Application for a non-material amendment following a grant of planning permission.
Town and Country Planning Act 1990

House:	<input type="text" value="10"/>	Suffix:	<input type="text"/>
House name:	<input type="text"/>		
Street address:	<input type="text" value="Foundation Square"/>		
	<input type="text"/>		
	<input type="text"/>		
Town/City:	<input type="text" value="AMBROSDEN"/>		
Postcode:	<input type="text" value="OX25 2AQ"/>

6. Non-Material Amendment(s) Sought

17/01137/REM

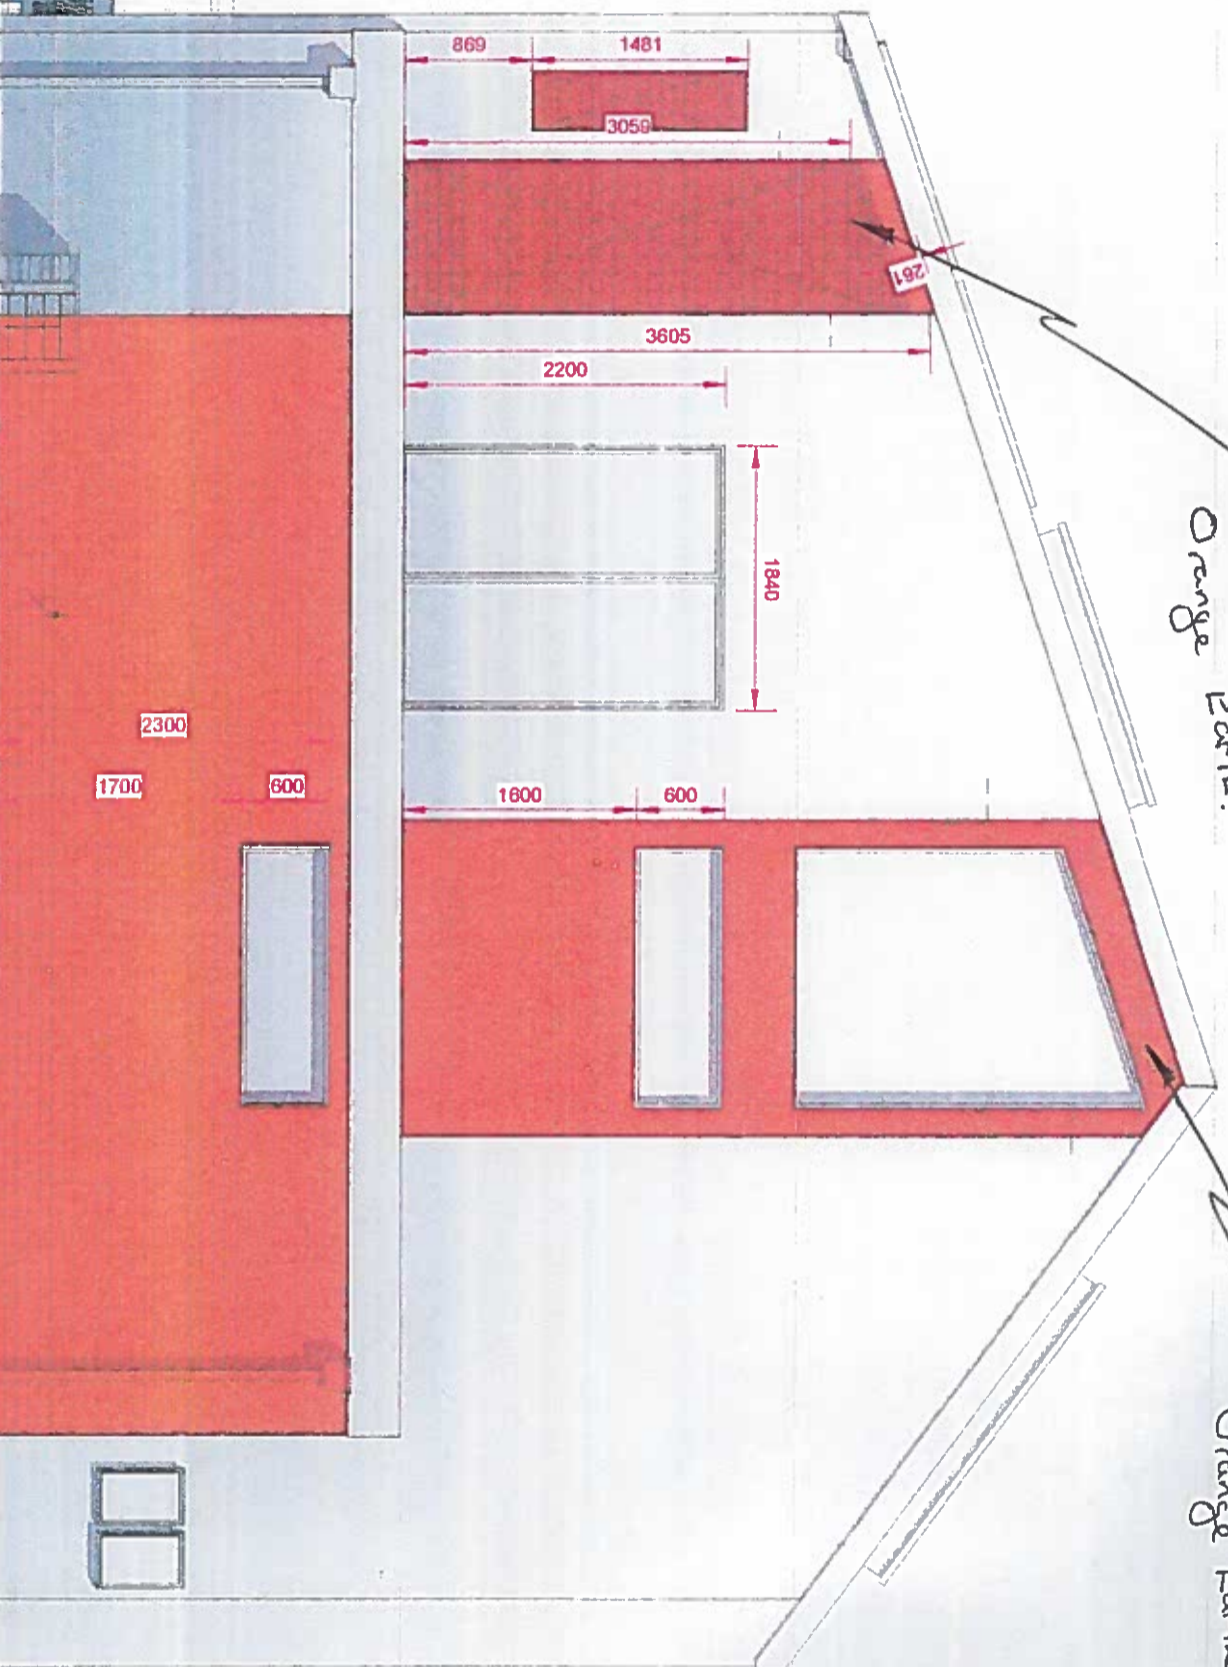
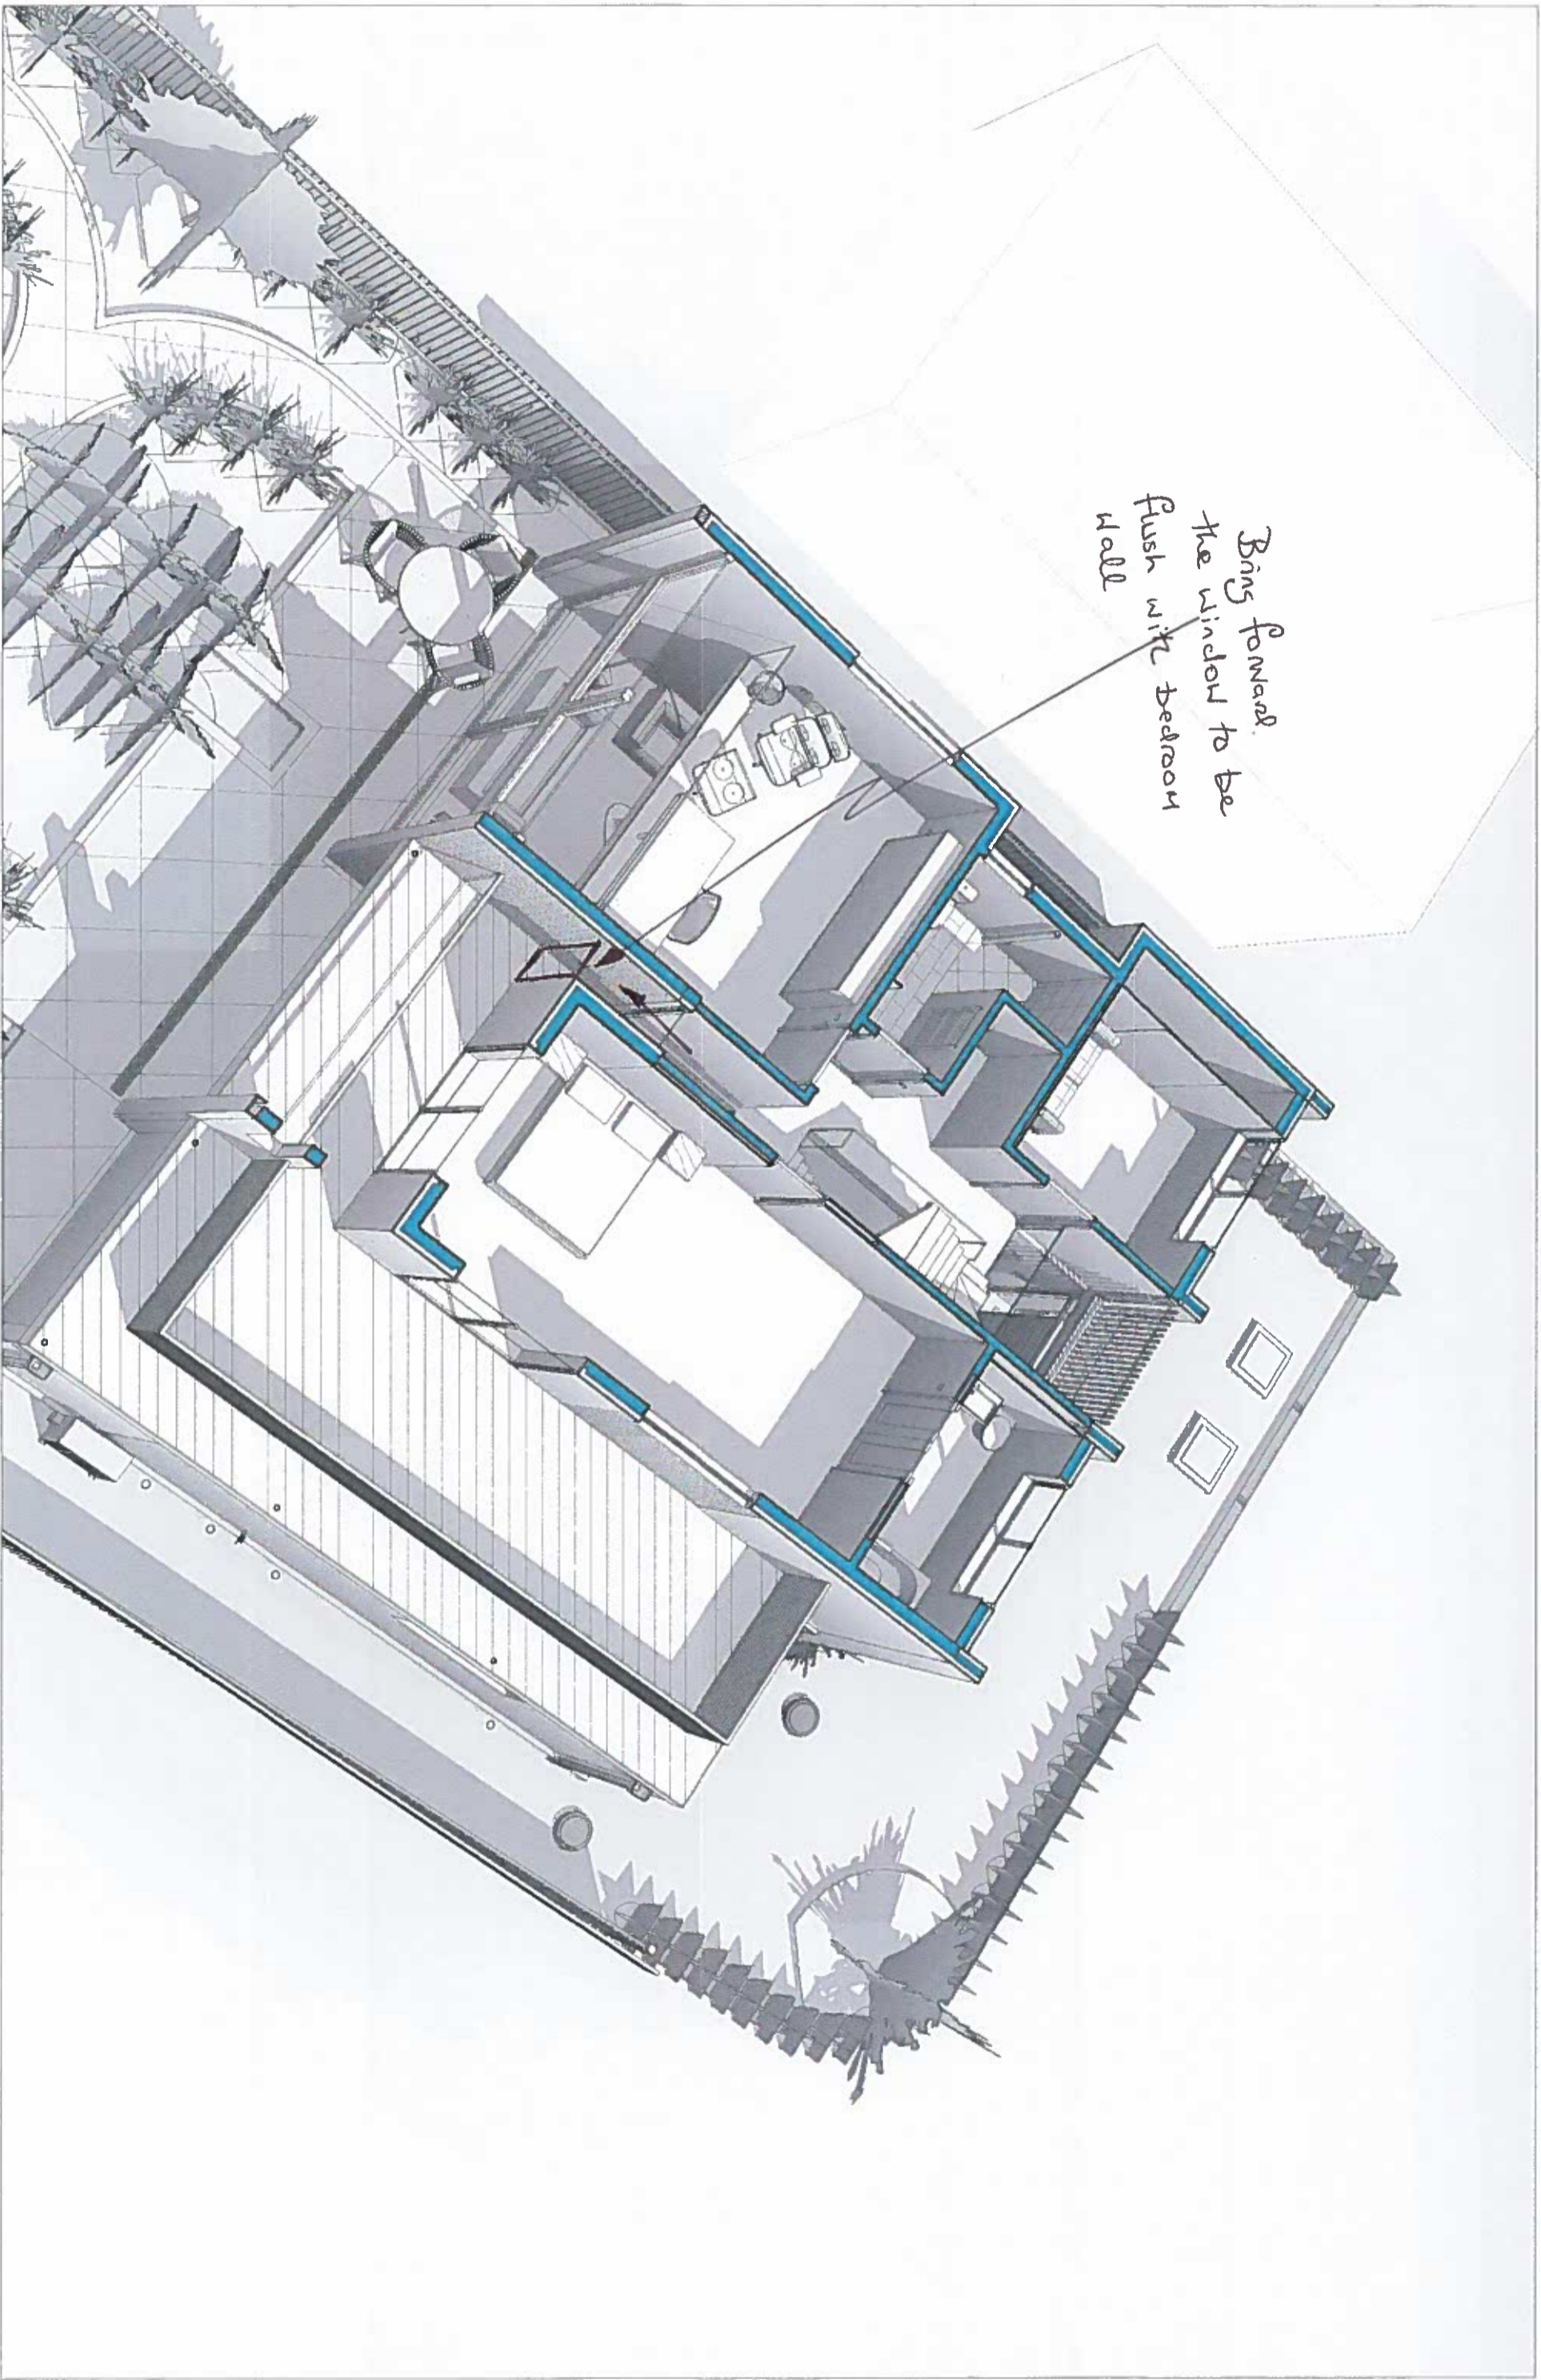
1. At the rear elevation the initial planning request was to have two rear opening doors with two panels above. the revised request is to have three doors with three panels above
2. On the original request bricks were selected for the 1st floor beside the bedroom balcony overlooking the garden and a panel extending from the 1st floor above the garage to the roof. the revised request is to have these areas rendered in a similar colour to the bricks
3. On the first floor beside the bedroom doors overlooking the garden the window into the hallway was set back, the revised request is to bring his window flush with the wall of the bedroom

1. we realised that the two doors would be too heavy for Sue to open and close safely and so wish to make them smaller and lighter so that she is able to operate them safely on her own
2. With the revised design where the 'indent' off the balcony and up to the roof level was removed and so the side of the house became flush. The construction was modified such that the structure would not support bricks and so we request to use render
3. the original position for the window resulted in an area that would be very dirty and would overall be more pleasant to have the window flush with the bedroom wall
